**Subject: DEVIATION REVIEW AND DECISION FORM**

Judge Orr Road RV Park & Storage  
Development

Section of ECM from Which Deviation is Sought: ECM Chapter 3 Section 3.2.5.E Water Quality and MS4 Permit Section 4.a.i(G)

DRAINAGE - DEVELOPED CONDITIONS

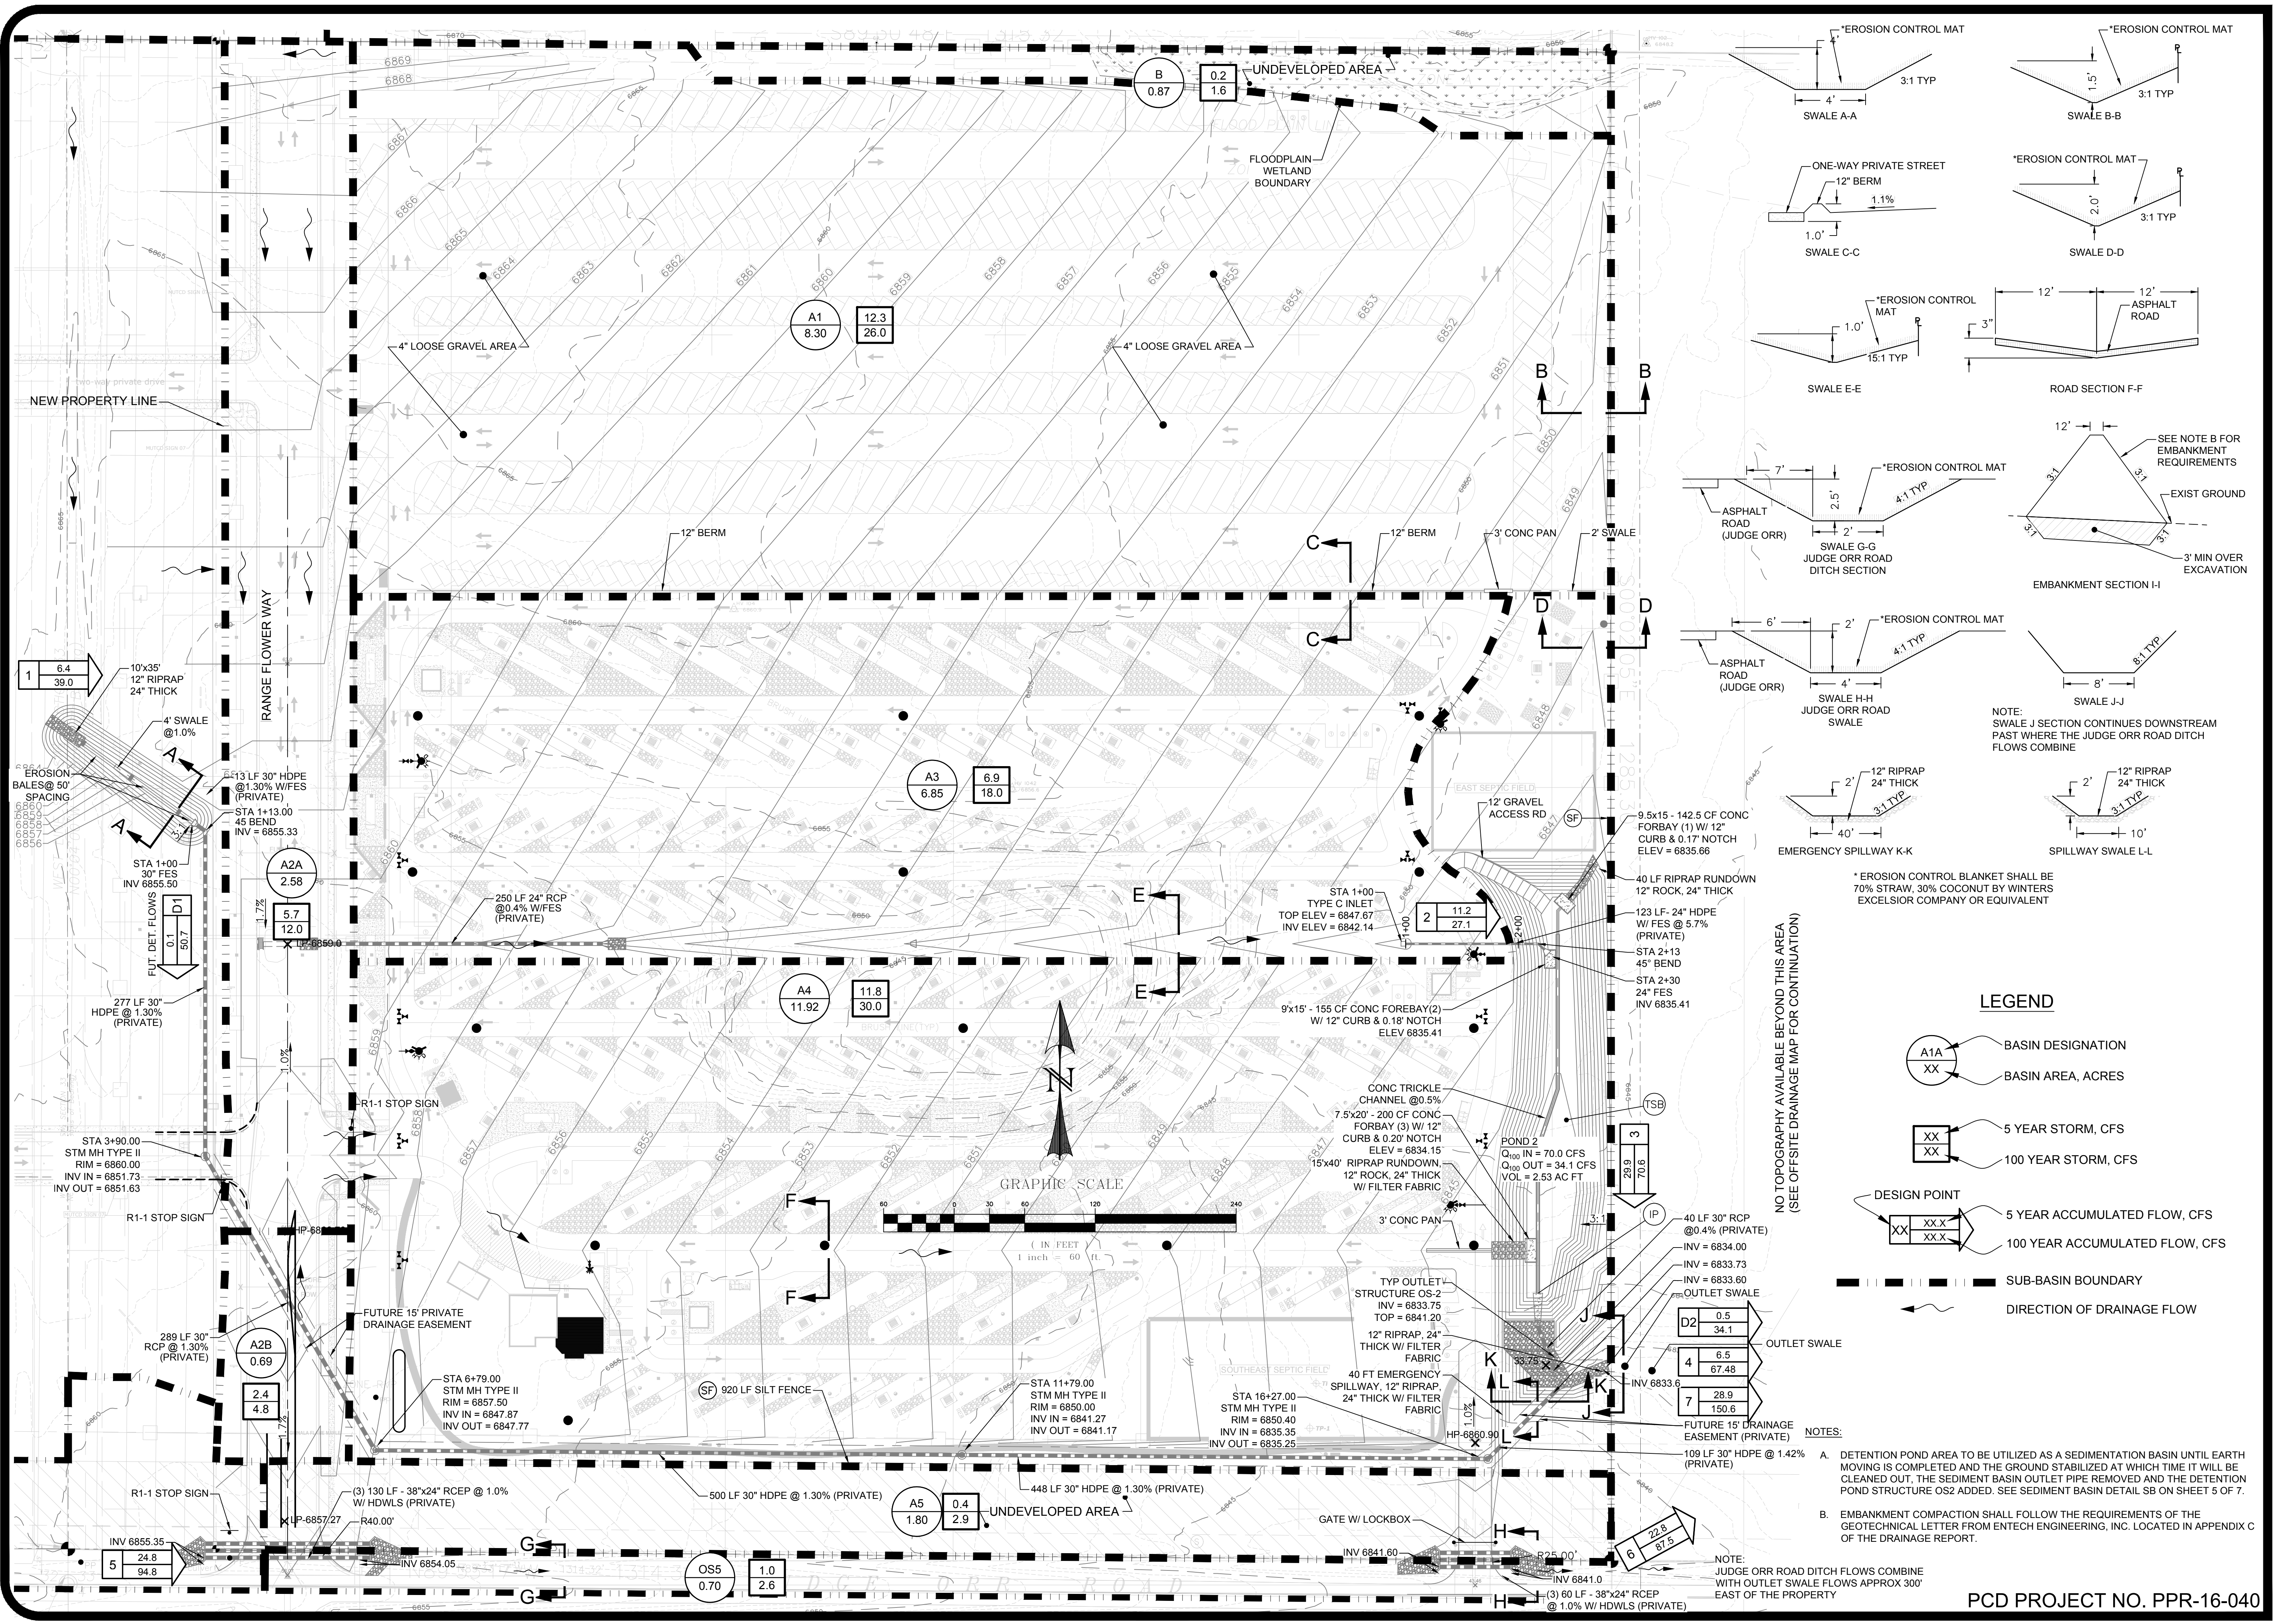
Two areas of the project area are not tributary to the water quality/detention basin:

Basins A2B and A5 contain 2.49 acres of which 0.74 acres are developed.

Basin B contains 0.87 acres of which none are developed.

Basins A2B and A5 developed area of 0.74 acres cannot reach the water quality/detention basin due to topography

The northeastern area will not be disturbed as a result of the site construction and the southern area only has two access roads crossing the area containing less than an acre of impervious area.

This request has been determined to have met the criteria for approval. A deviation from Section ECM 3.2.5.E of ECM is hereby granted based on the justification provided. Comments:

ECM updates approved 7/2019 now allow for this provision, however at the time this site was submitted for approval, the ECM had not been updated to allow for all the same provisions as the MS4 permit.
